**KIRKLEES METROPOLITAN COUNCIL  
INVESTMENT & REGENERATION SERVICE**

**DELEGATED DECISION TO DETERMINE PLANNING APPLICATIONS**

Reference No:	<b>2025/62/91829/E</b>
Site Address:	145, Headfield Road, Savile Town, Dewsbury, WF12 9JJ
Description:	Erection of side dormer
Recommending Officer:	Faiza Bano

## HOUSEHOLDER DELEGATED REPORT

| DRG: PROPOSED PLANS & ELEVATIONS | |

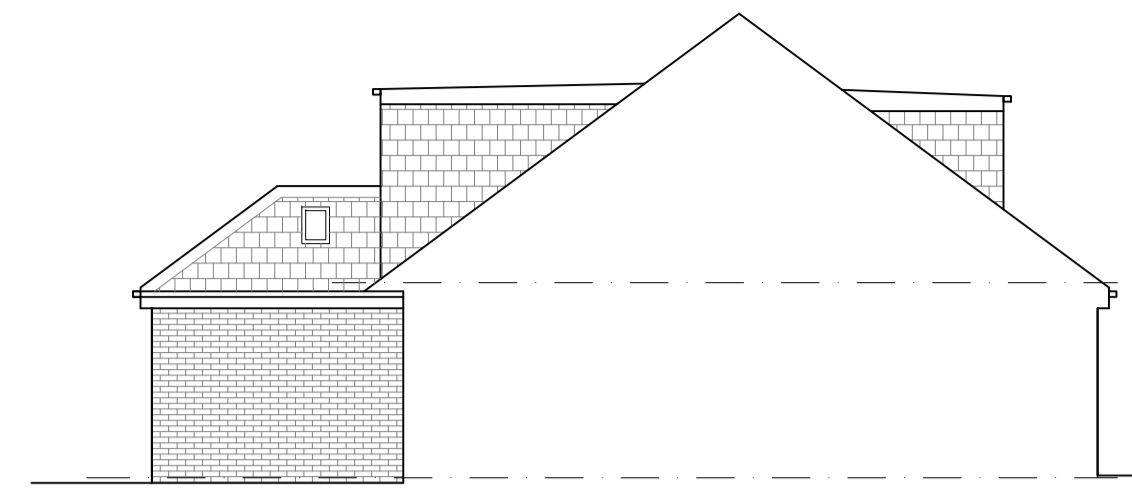
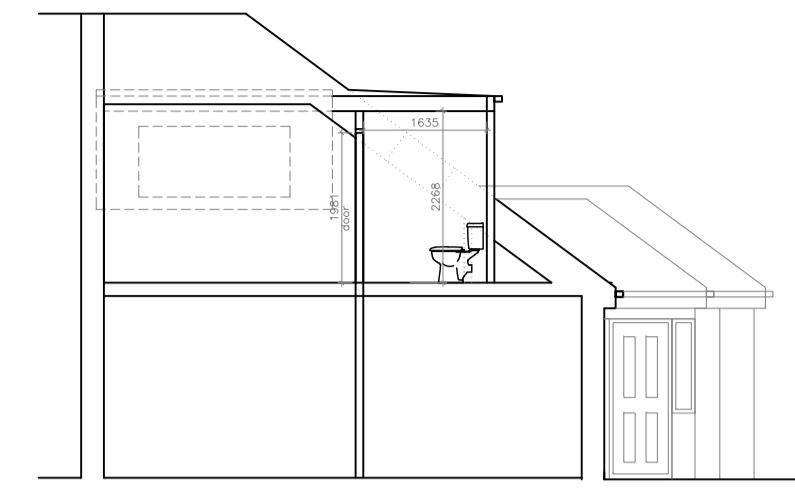
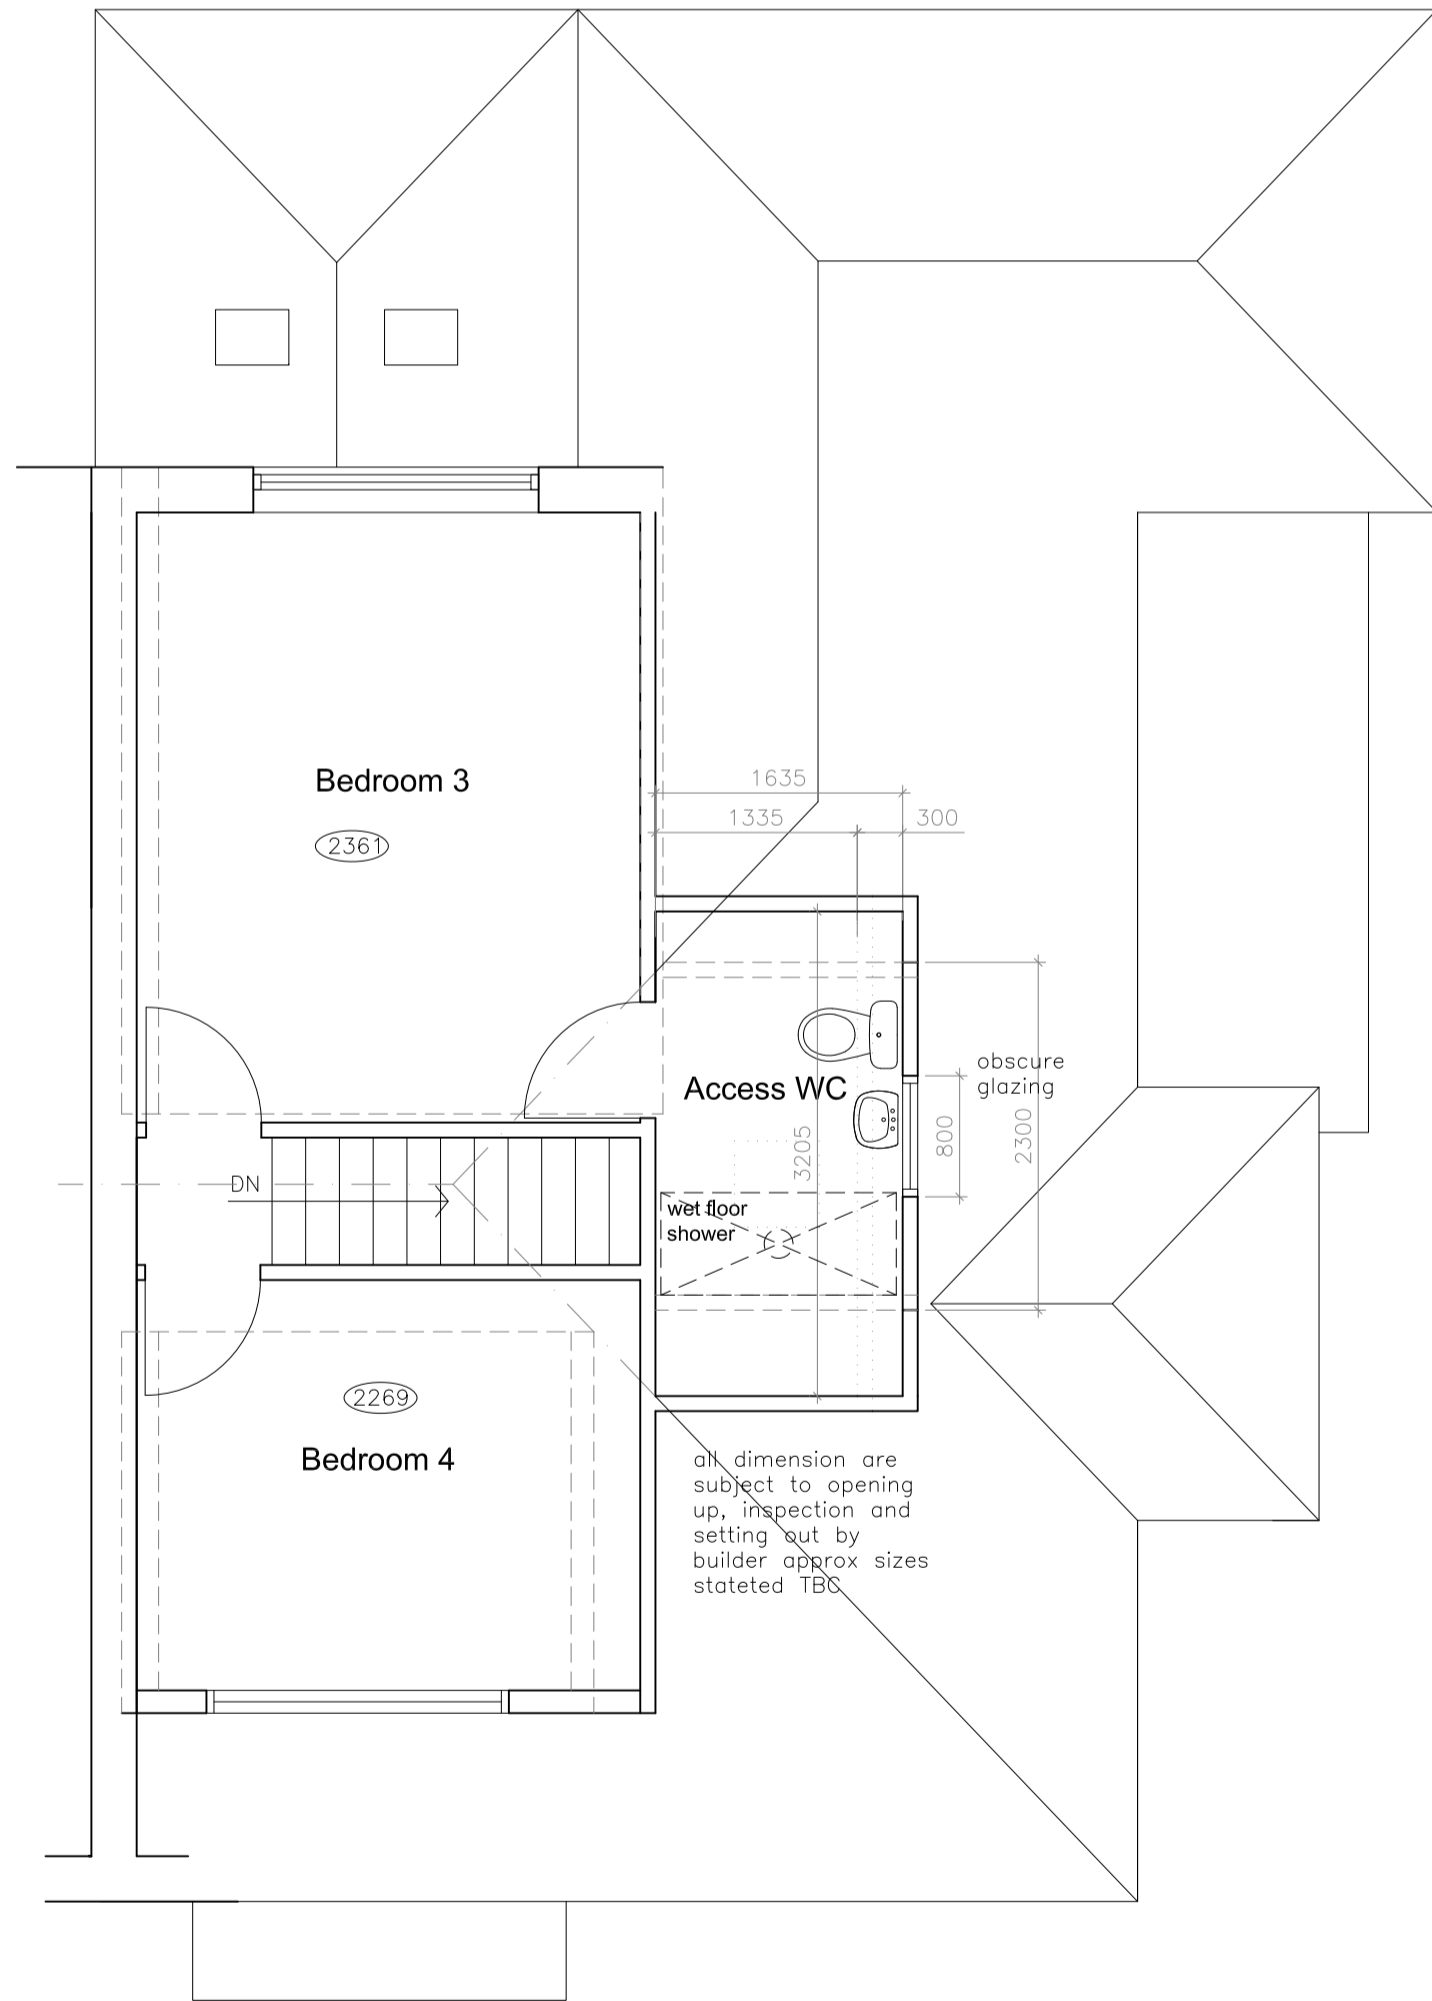
The application is seeking planning permission for erection of side dormer extension, facing the southeast. The dormer spans a width of 3.4m, 1.7m in depth and 1.6m in height. The dormer is flat roofed and has a tile finish to match the existing roof.

Internally, the dormer would serve as an accessible bathroom with an obscurely glazed window.

<p>relate to the appearance of the house and existing roof</p>		<p>The dormer is designed with a flat roof, which is consistent with previously approved dormers and existing roof.</p> <p>Flat roofs are common for dormer extensions in the surrounding area. For these reasons, the proposed roof design is acceptable in this case.</p>
<p>be designed in style and materials similar to the appearance of the existing house and roof</p>	<p>The dormer is to be finished with tiles that match the existing roof, which creates a harmonious overall appearance.</p>	
<p>not dominate the roof or project above the ridge of the house</p>	<p>The dormer is of a modest scale and sits below the principle roof ridge. The irregular hipped roof of the dwelling prevents the dormer from over dominating the original dwelling's street-facing elevation.</p>

be set below the ridgeline of the existing roof and within the roof plane	Dormer is set below the ridgeline of the existing roof and is within the roof plane.	
be aligned with existing dormer windows on neighbouring properties in the same roof plane where relevant	There are no side dormer windows on neighbouring properties in the same roof plane. However, dormers are present on other roof planes, and it is considered that the proposed dormer is in line with the existing.

Impact on original house	KDP2 of the SPD Policy LP24 Design (c) and (d) of the KLP Policy 1 & 2 of the HVNDP Chapter 12 of the NPPF	The dormer is set down and set back from the front allowing the original roof form to remain clearly visible around it at the front.  This design prevents the dormer from appearing disproportionate or dominant on the host dwelling's roof.	✓
Height, scale and massing	KDP 1 and 2 of the SPD Policy LP24 Design (a), (c) and (d) of the KLP <ul style="list-style-type: none"> <li>• Policy 1 &amp; 2 of the HVNDP</li> <li>• Chapter 12 of the NPPF</li> </ul>	Acceptable for the reasons above.	✓
Facing materials and detailing	<ul style="list-style-type: none"> <li>• KDP 9 of the SPD</li> <li>• Policy LP24 Design (d) (iii) of the KLP</li> <li>• Policy 1 &amp; 2 of the HVNDP</li> <li>• Chapter 12 of the NPPF</li> </ul>	The proposed finish matching the existing roofing materials.	✓

Roof style	<ul style="list-style-type: none"> <li>• KDP 1 and 2 of the SPD</li> <li>• Policy LP24 Design (a), (c) and (d) of the KLP</li> <li>• Policy 1 &amp; 2 of the HVNDP</li> <li>• Chapter 12 of the NPPF</li> </ul>	Flat roof – visually acceptable appearance. Additionally, this style is consistent with similar dormer extensions in the surrounding area.	✓

- 143 Headfield Road – No impact on this dwelling as the proposed works are located on the other side.
- 147 Headfield Road – There is considered to be minimal impact on this dwelling, owing to the presence of an obscurely glazed window and the fact that any potential overlooking would be directed toward the roof plane of the property. While the two dwellings are in relatively close proximity, the proposal is not anticipated to result in any significant harm in terms of overshadowing, loss of light, outlook, or privacy.
- There are properties to the front and rear, however given that the former faces the southeast, it is considered that there will be no impact on these dwellings.

4. The development shall not be occupied until the bathroom window on the dormer hereby approved has been obscurely glazed (to a minimum Grade 4). Notwithstanding the provisions of the Town and Country Planning (General Permitted Development) Order 2015 as amended (or any Order revoking or re-enacting that Order) the obscure glazing (to a Grade 4) shall thereafter be retained.
